Application No: K/55/20/PL
Site Address: 57 Coastal Road Kingston BN16 1SN
Description of works: Demolition & erection of 1 No. dwelling. This application is in CIL Zone 4 and is CIL Liable as new dwelling.

Thank you for your internet representation made on 19th January 2021 which has been recorded as an objection with the comments as follows:

For ST Charles Homes LTD	
Drawing Proposed Plans&Elevations	
Project La Casa, 57 Coastal Road, West Kingston East Preston BN16 1SN	
Scale	1:100
Date	19.11.2020
Made by Arch. Grygorieva A.A.

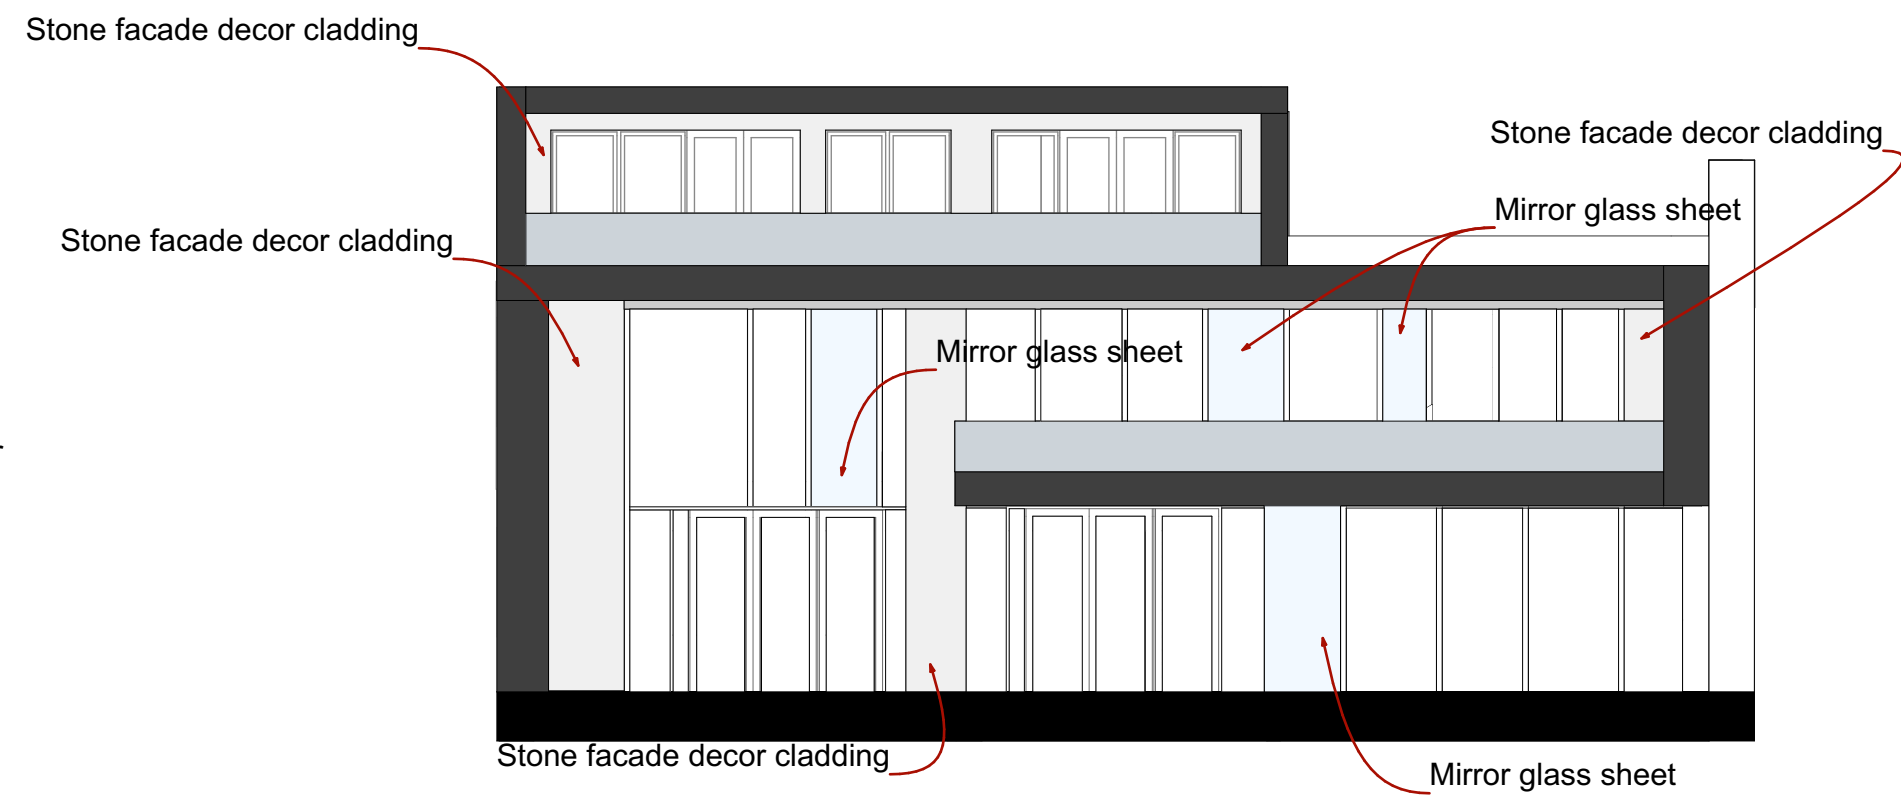
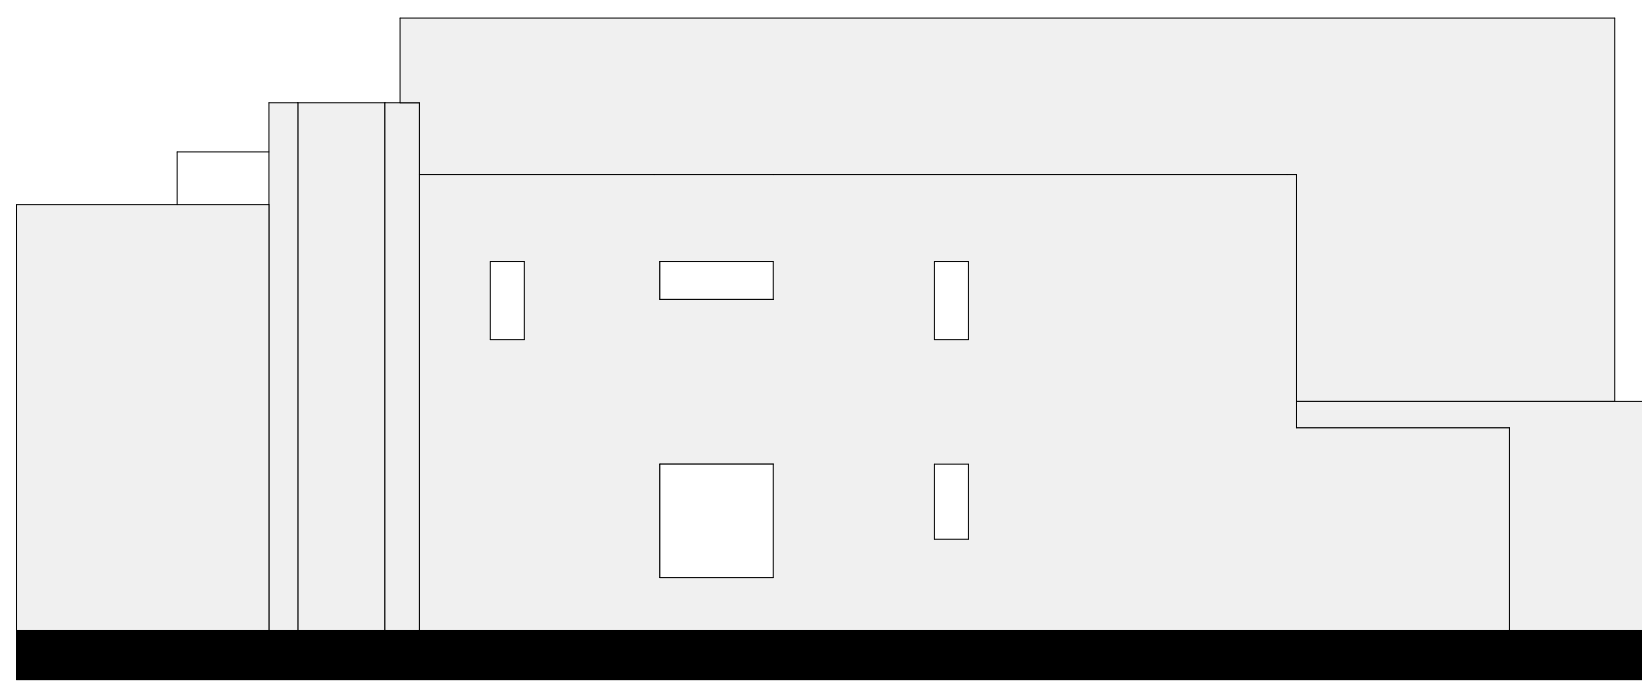
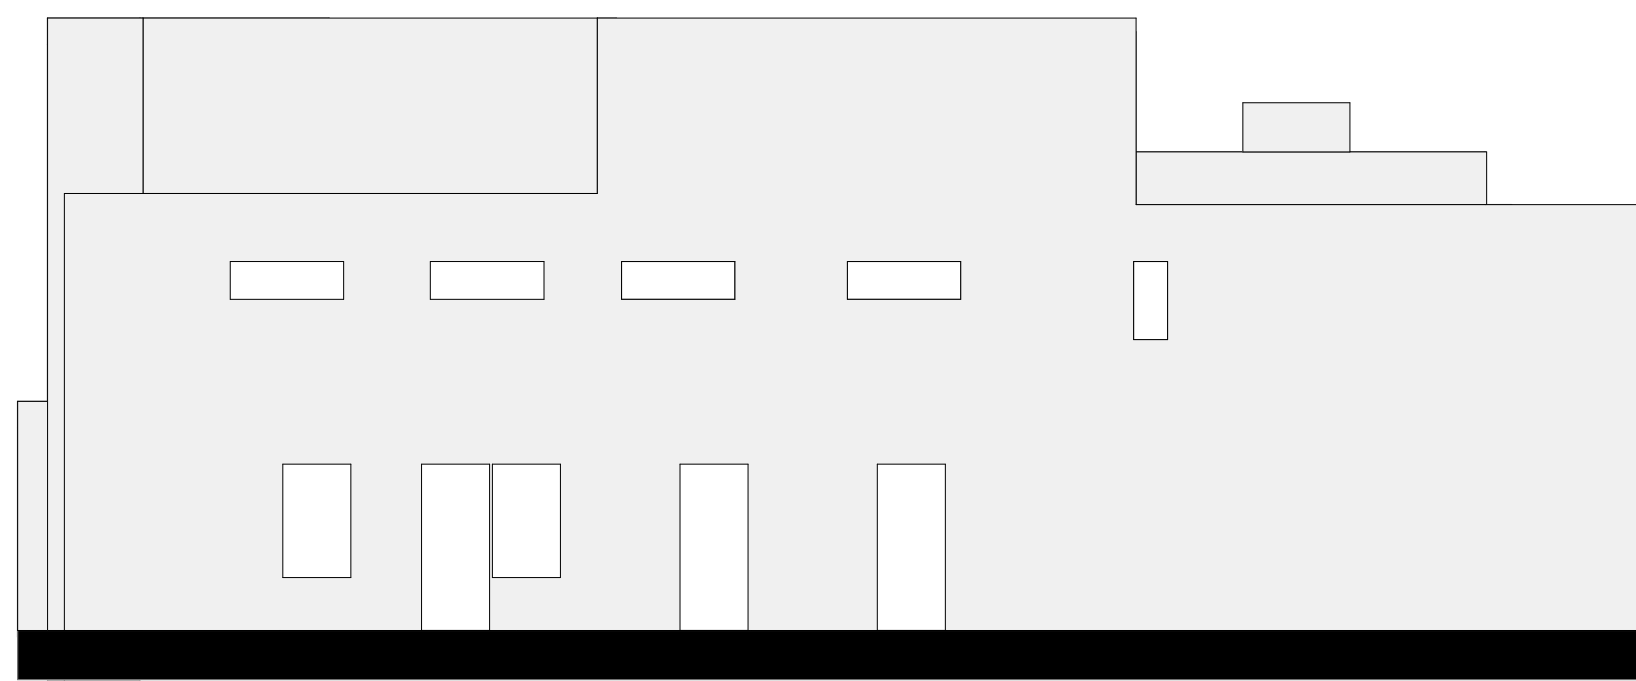
This application is totally out of keeping with the surrounding properties. It is aggressive in its design and not sympathetic to the surrounding neighbourhood. The proposals to use mirrored glass and other materials are totally out of keeping. The build would be out of line with the building line and ridge height is excessive. Contrary to KPNP7 and would be dominant and intrusive to neighbouring properties.
